SUBJECT: LU/201/16/RES - Approval of reserved matters following outline consent
LU/229/10/ for appearance, landscaping, layout & scale for 84 No. dwellings.

Amendment.

Windroos Nursery, Worthing Road, Littlehampton, West Sussex, BN17 6LY

VISIBILITY ADJACENT TO PLOTS 53, 63 AND 62

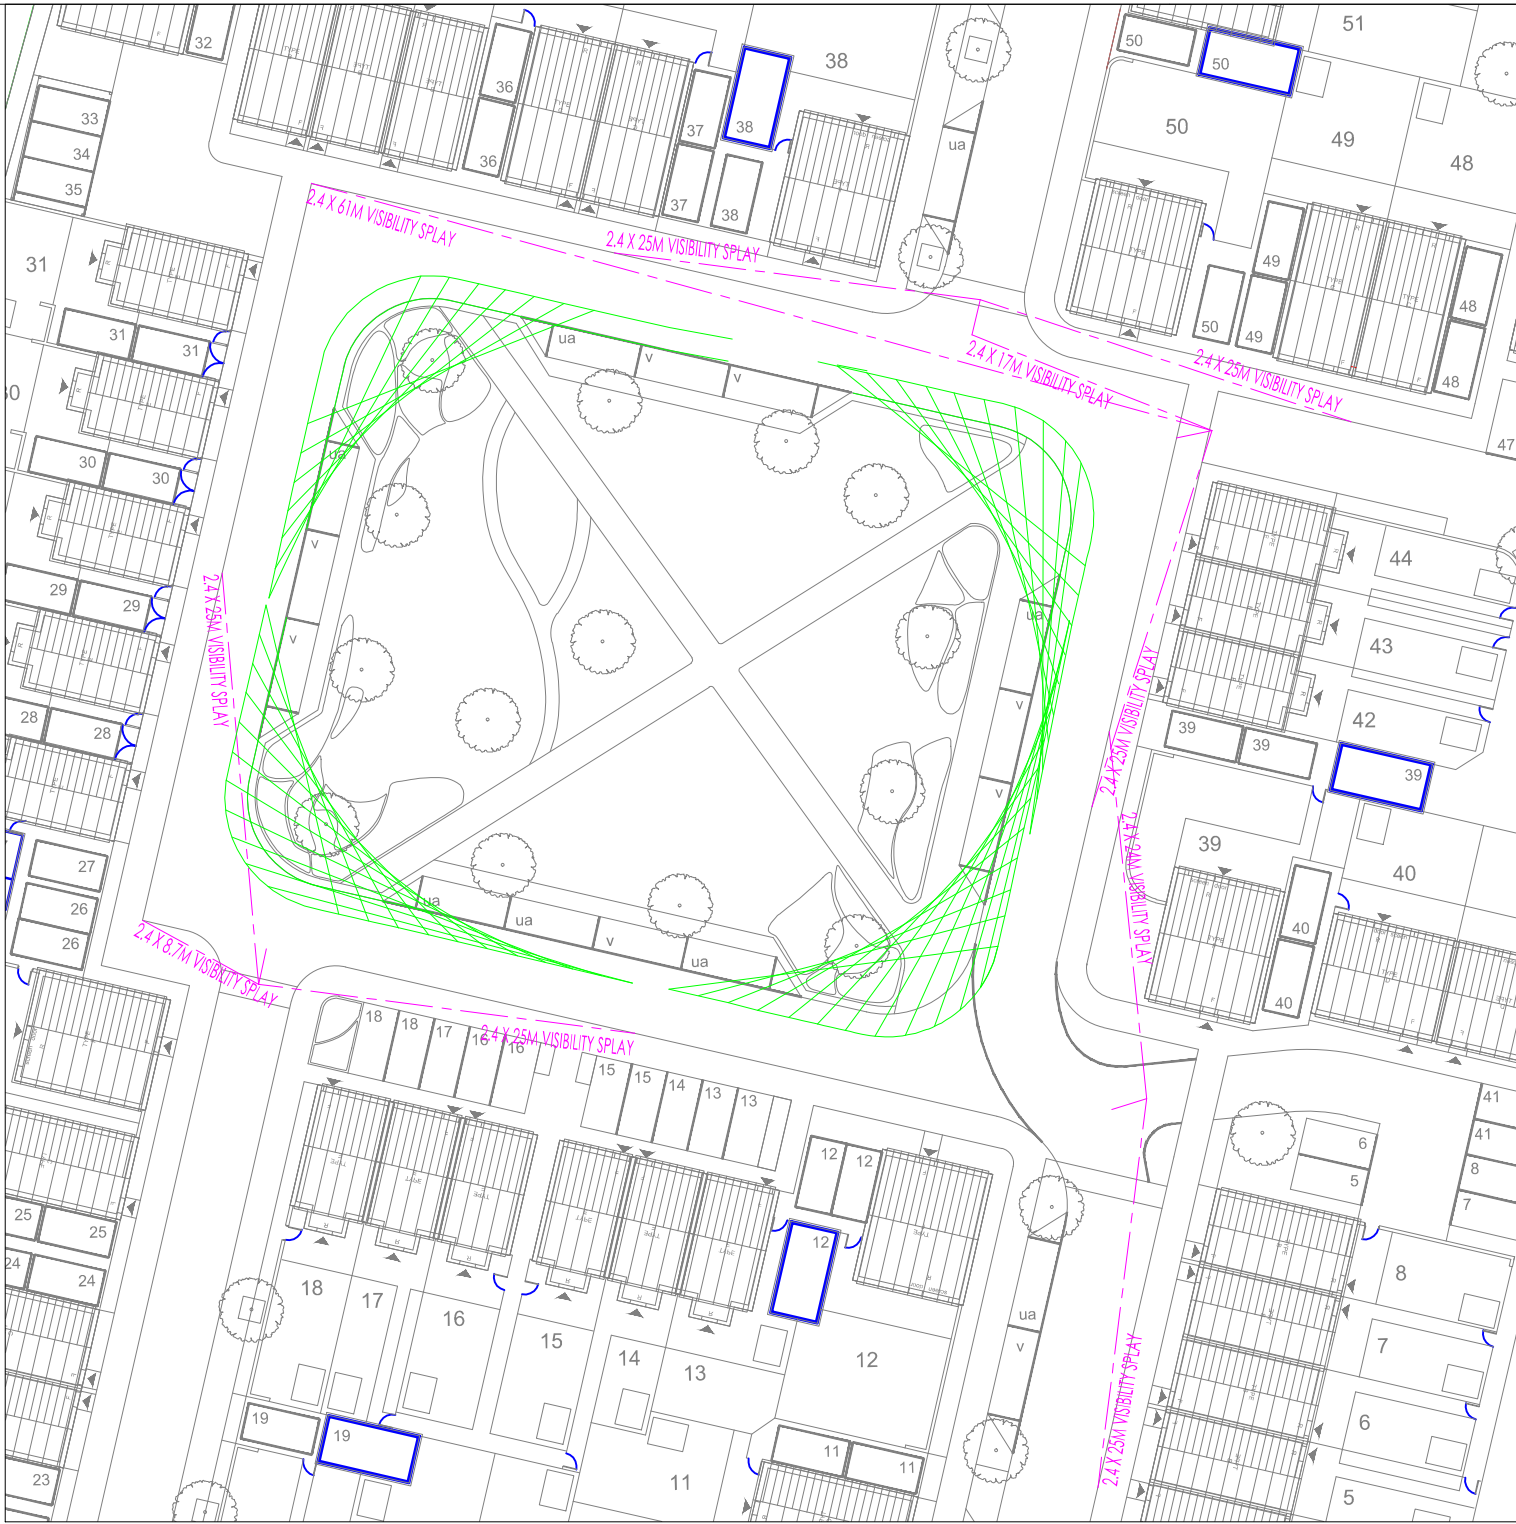
- The kerb radii at the junction at the frontage of plot 63 should be enlarged as much as possible. The logic of the layout shown is acknowledged (that there is no through route from the proposed development into the adjoining completed development and as such there would be no reason for traffic to turn right). However the Design Brief for Site 7 (which incorporated both the adjacent completed and currently proposed development) envisaged a through route. Whilst there is a ransom strip between the two sites at present, this may be overcome. The design should be altered to reflect this.*

The kerb radii have been removed altogether and the access road indicated as being private. Putting aside matters of land ownership/control, whilst this would not preclude a through access in principle for pedestrians, given the alignment proposed does not reflect that within the adjoining development, it would be difficult to connect the two sites together for vehicle traffic.

CLIENT	STUART & MARCIA LYONS
PROJECT	WINDROOS, LITTLEHAMPTON
TITLE	PROPOSED SITE PLAN - RESPONSE TO RESERVED MATTERS COMMENTS

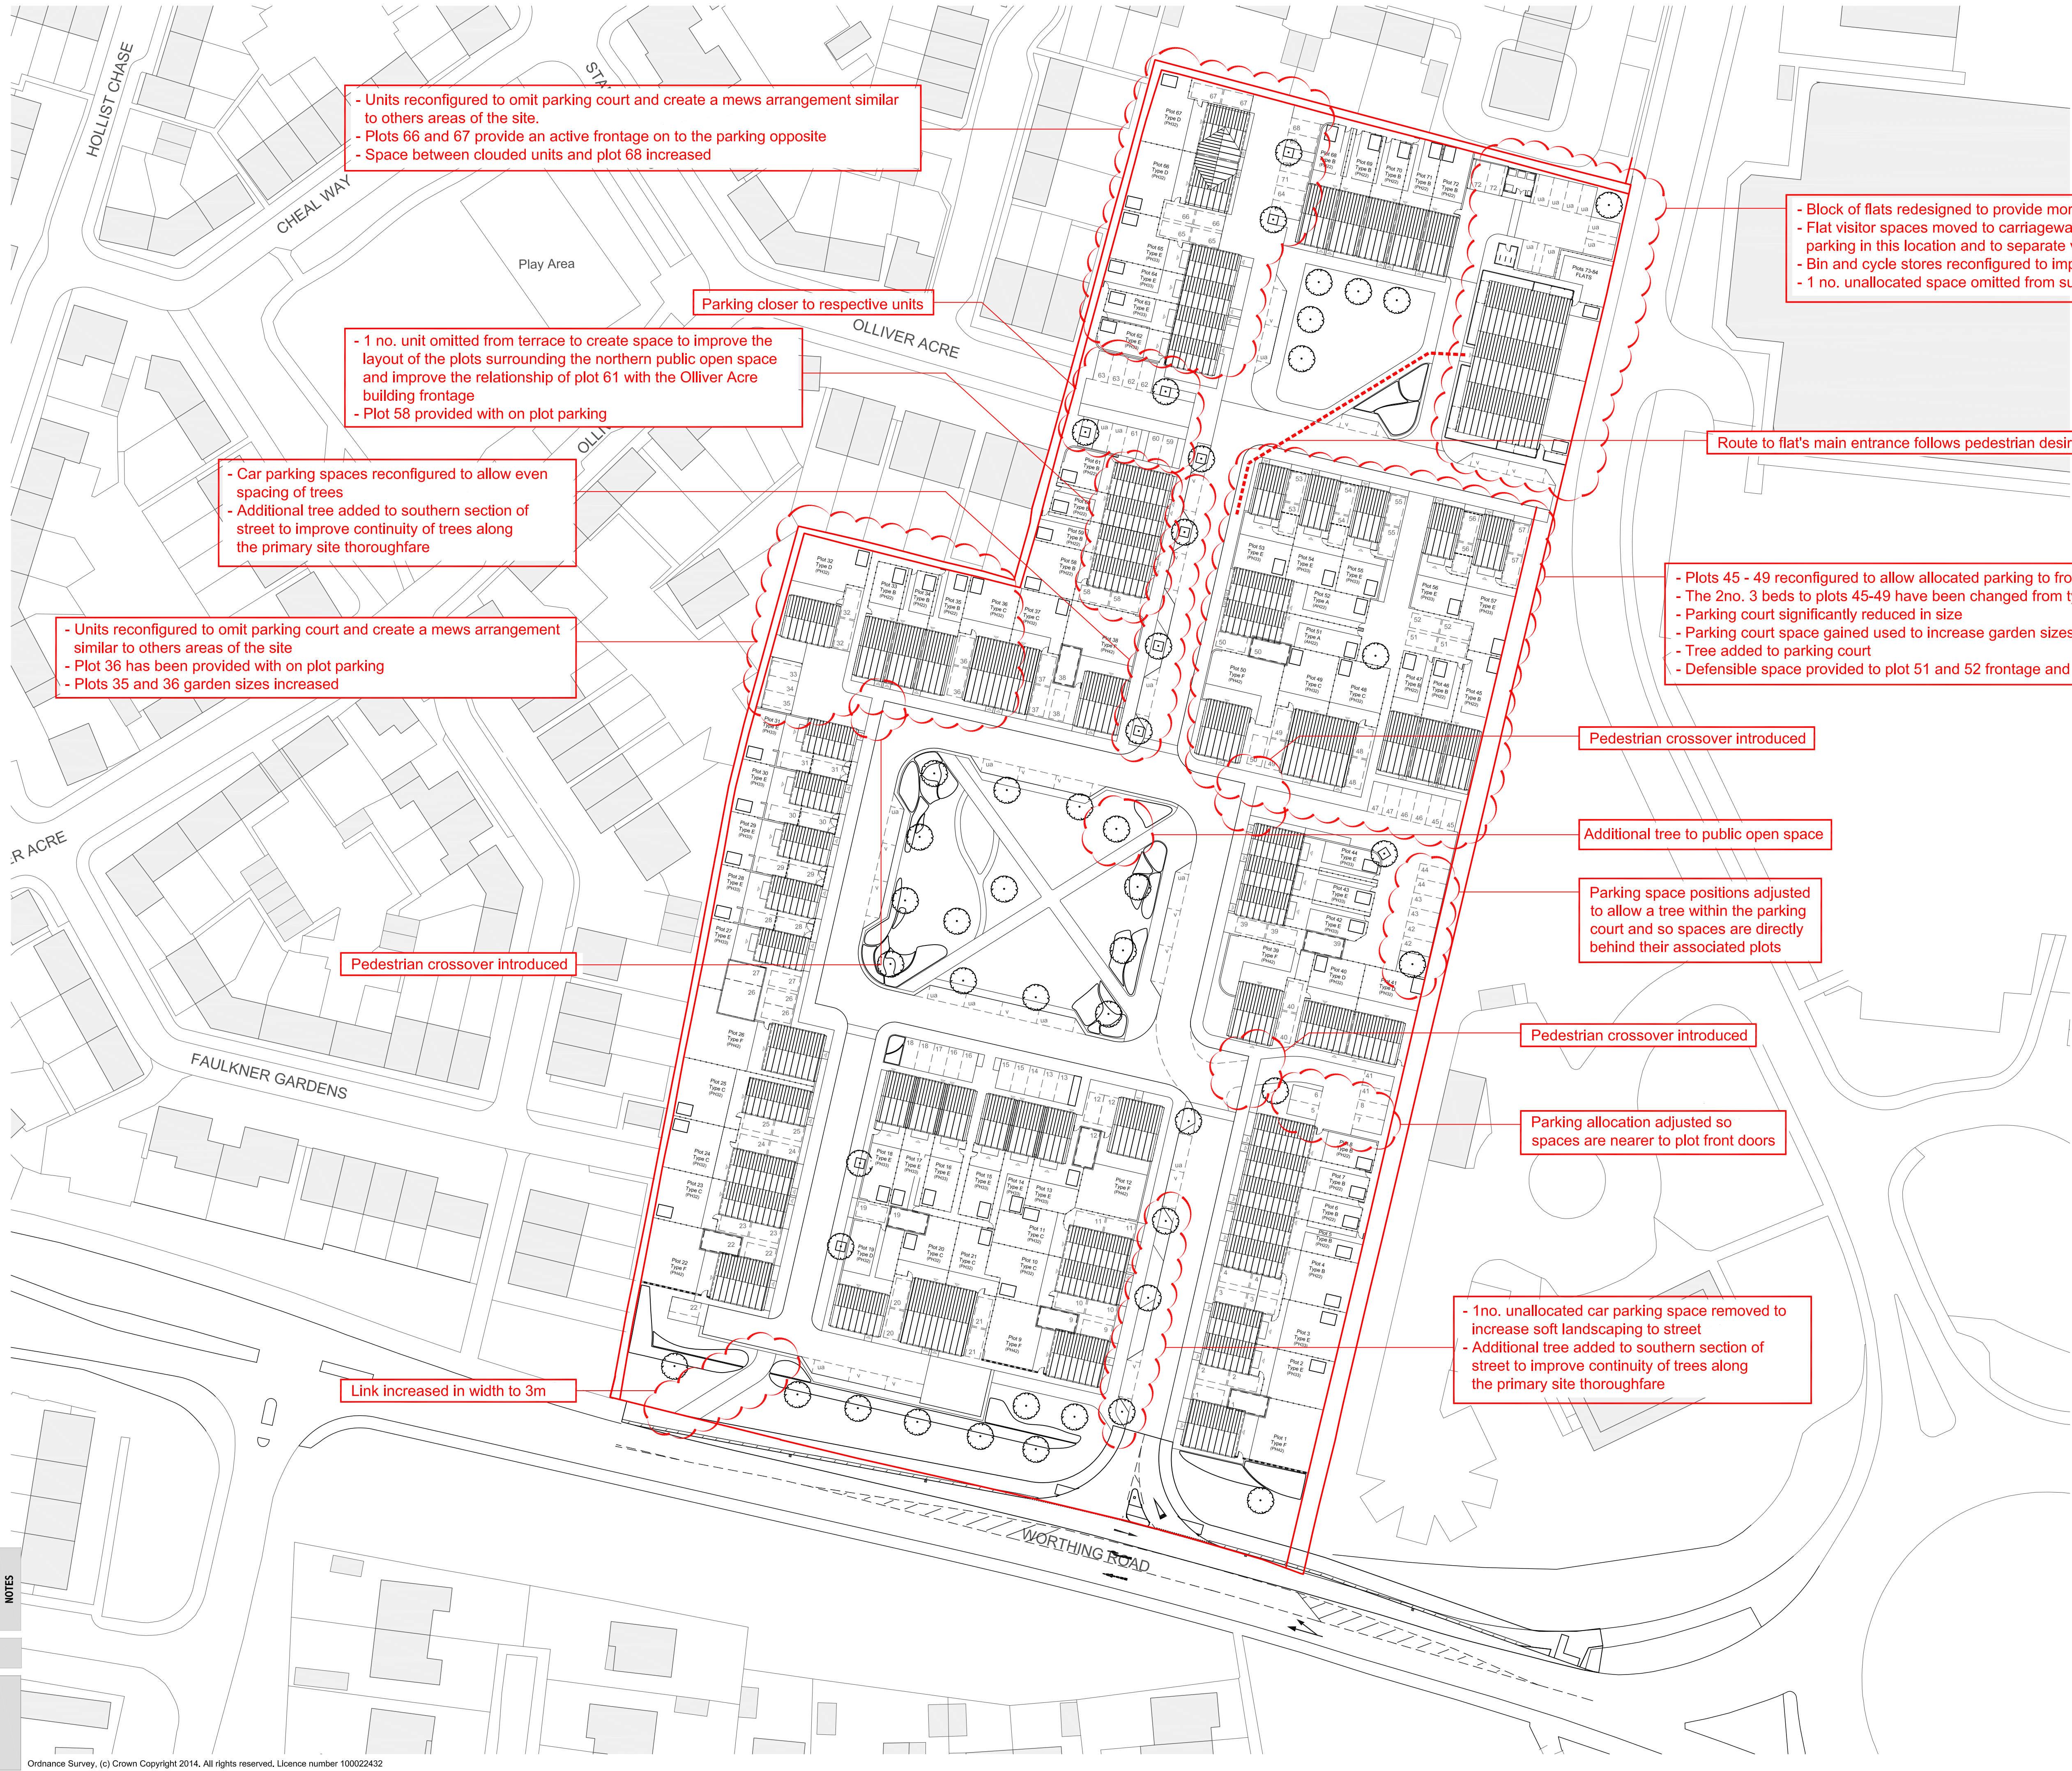
- A separate pedestrian access is shown onto the A259. There is an unsegregated foot/cycle way along the north side of the A259 in this location. Ideally this access into the development would be widened to 3 metres to continue the unsegregated foot/cycle way into the development.*

- It is recommended that the parking spaces north of plot 62 are located behind the footway instead of the layout as shown. This would make defining the extent of adoption more straightforward, i.e. it would be the back edge of the footway. Given that the exact extents of adoption are not clear, it may well be that this access road is not being offered for adoption.*

- *In connection with the above, there are quite a number of side roads where it appears that these will be accessed by formalised bellmouths with kerb radii. Given the low number of parking spaces served from these, these could alternately and more preferably have been accessed by crossovers. This would then give priority to pedestrian movements rather than vehicular traffic.*

The link has been increased to 3 metres.

The parking spaces have been moved to the back of the footway. This length of access road is in any case now shown as being private.

The layout has been altered in certain instances to give greater priority to pedestrian movements.
